Project Submittal Interim Form

Project Name: * Bridge No. 87 on NC 33 over Norfolk Southern Railroad, (B-5301 Central)

Date: 18 January 2022
TIP Number: B-5301
County: Pitt
Description: Bridge No. 87 over Norfolk Southern Railroad on NC 33

B-5301 NEU Environmental Permit Narrative

5/14/99  
26-185-22  
13218  
LISTED: 10/10/16  
ut\_rdy5\_u03\_psh.dgn  
3/20

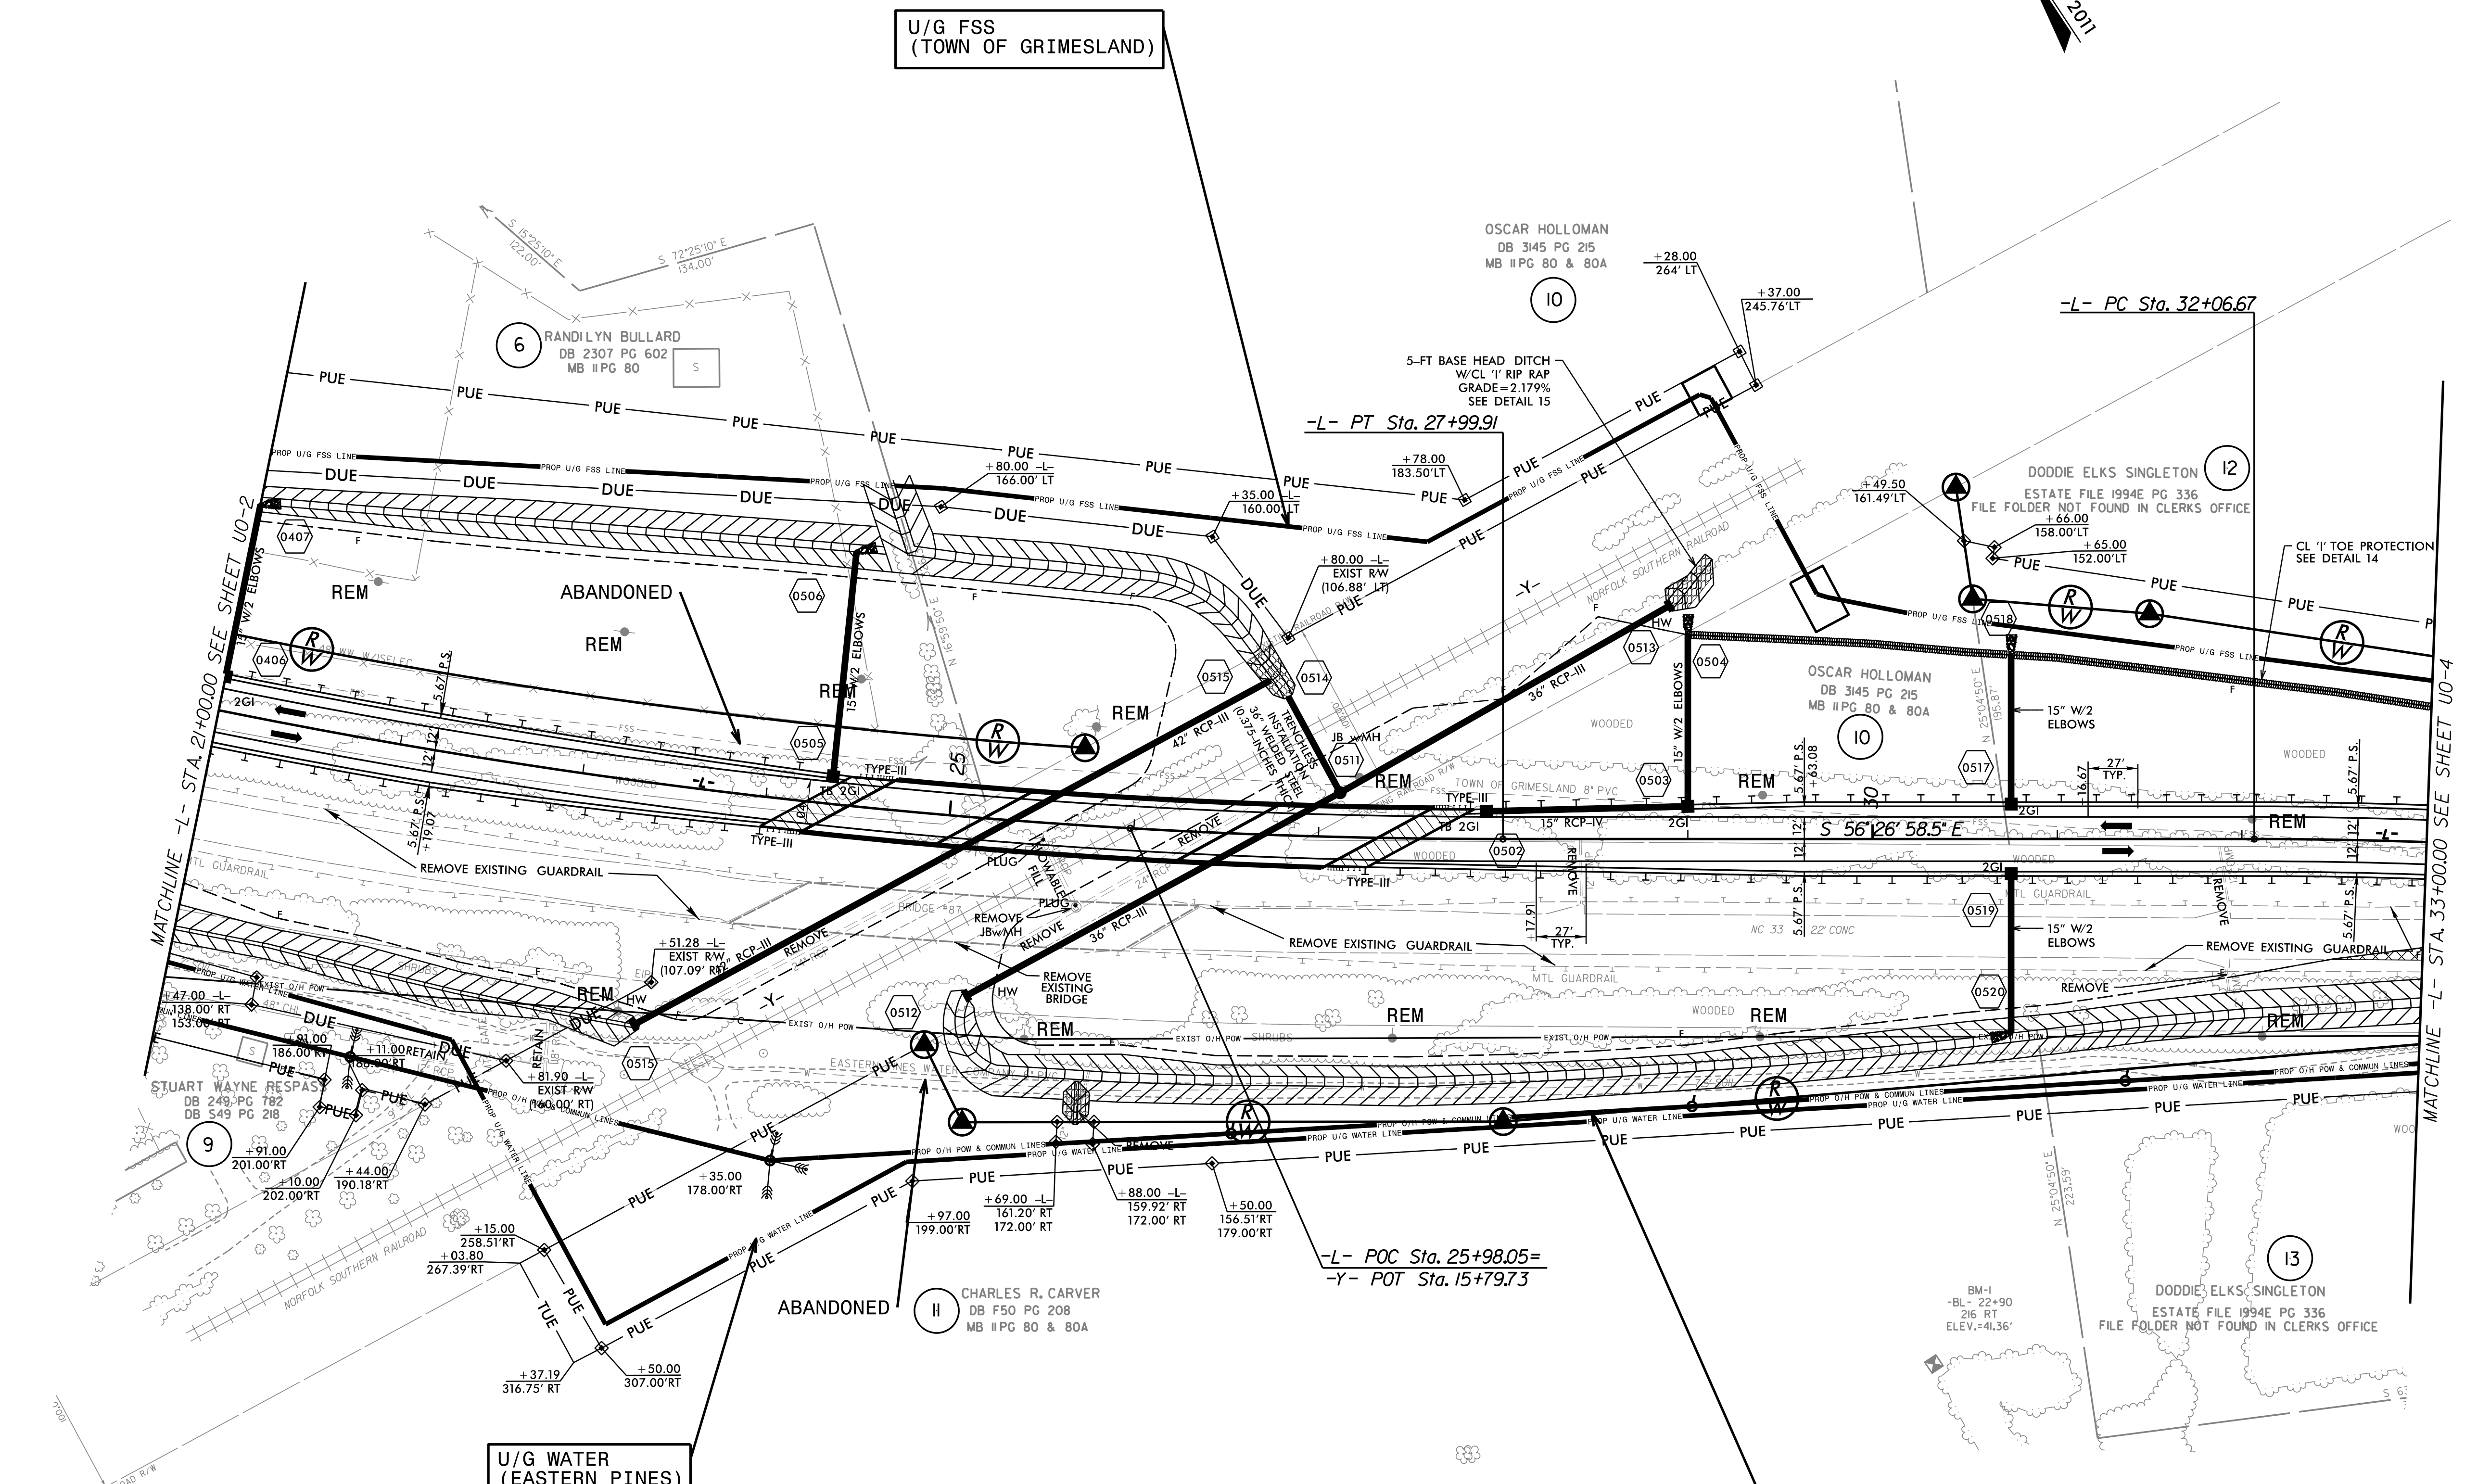
The project now involves utility impacts not anticipated in the original application, which are explained in the attached narrative and utility drawings. This will involve an additional 0.021 acre of permanent impact as an area permitted as hand clearing will be excavated. See call out box on permit drawing (sheet 2 of 2) depicting new proposed impacts in relation to previously permitted impacts for mechanized clearing and hand clearing.

The Town of Grimesland will replace their existing sewer system along the north side of NC 33. The railroad crossing will be core and jack with a launch pit located in the wetlands. There will be approximately 0.03 acres of excavation for the bore pit and 0.02 acres of temporary fill. To minimize wetland impact the wetland crossing will utilize the same launch pit and directional drill to a receiving pit outside the wetland area. (See sheet UE-4).
